Please ask for: Ms Iqraa Malik  
Email: [iqraa.malik@terraquest.co.uk](mailto:iqraa.malik@terraquest.co.uk)  
Telephone: 01212341390  
Our Ref: BR/275/20/HH  
Your Ref:  
Date: 20th November 2020

**Application for Planning Permission for Works or Extension to a Dwelling**

**Development:** Proposed rear conservatory  
**Location:** 53 Highcroft Crescent Bognor Regis PO22 8DJ

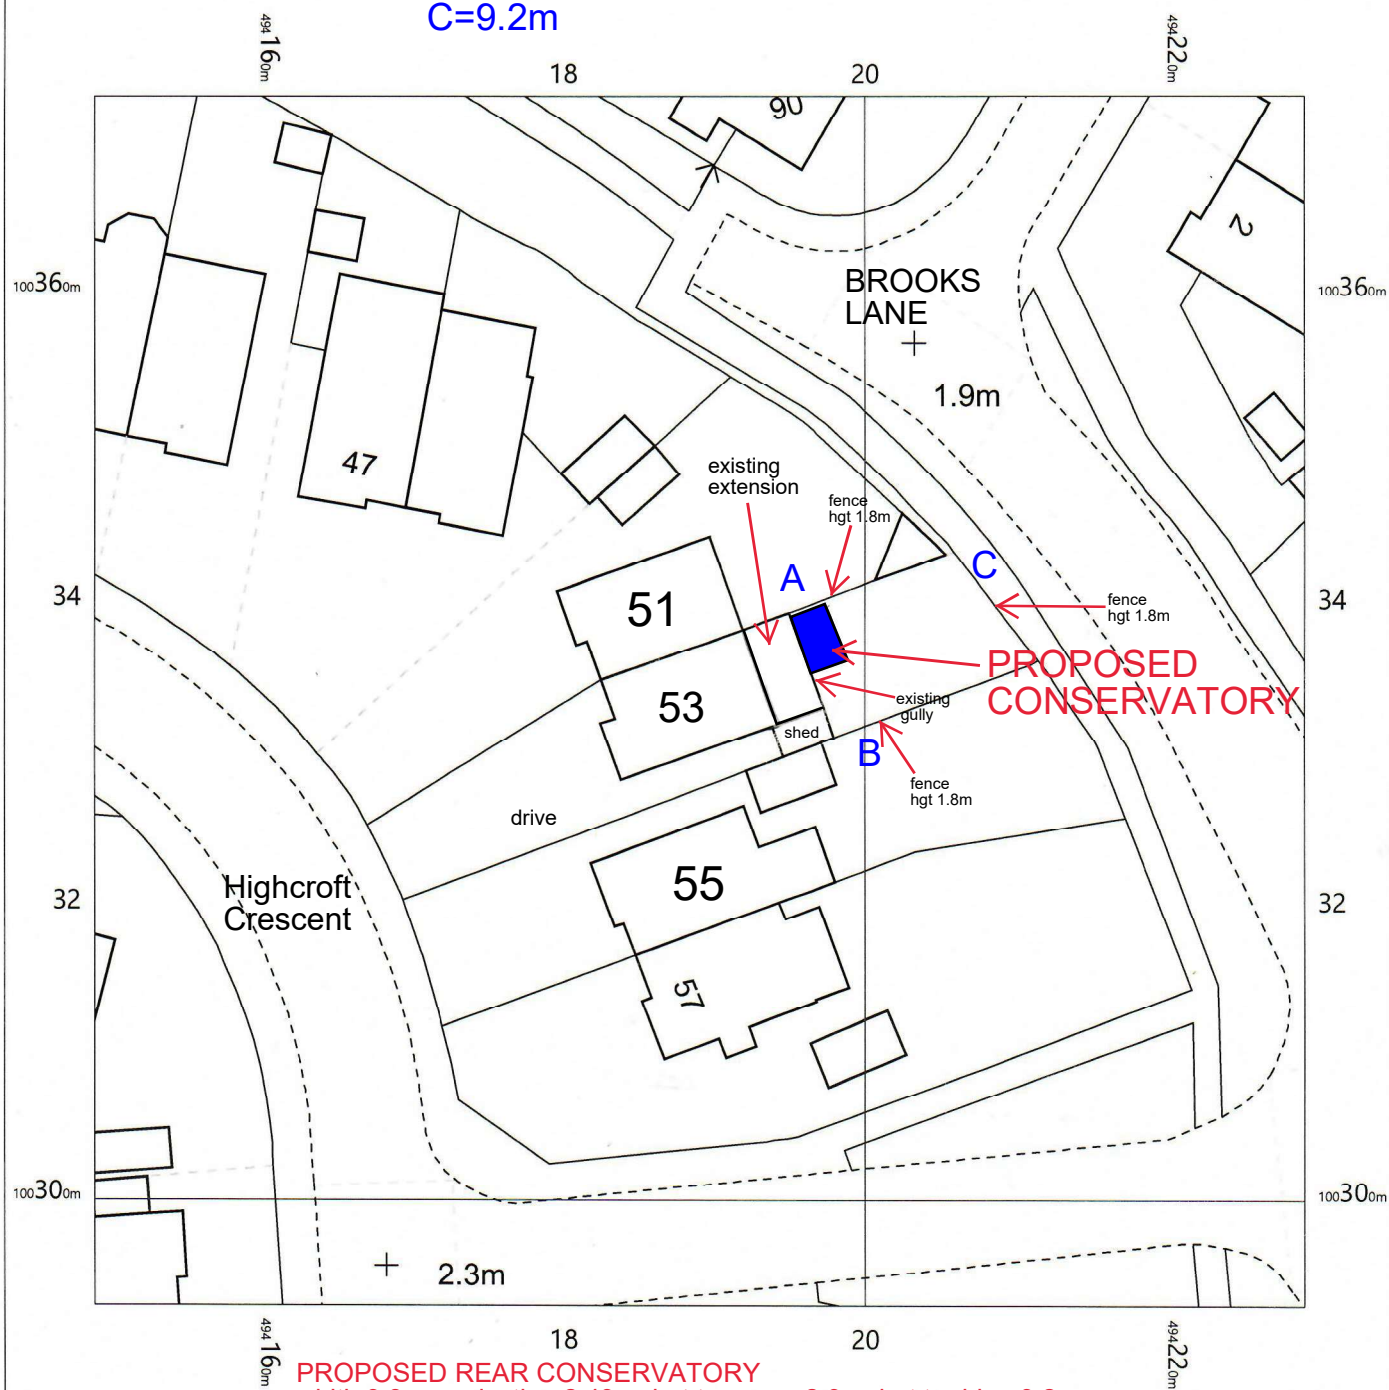
**Block Plan**

You are required to have dimensions from the proposed extension(s) to all site boundaries. Please amend.
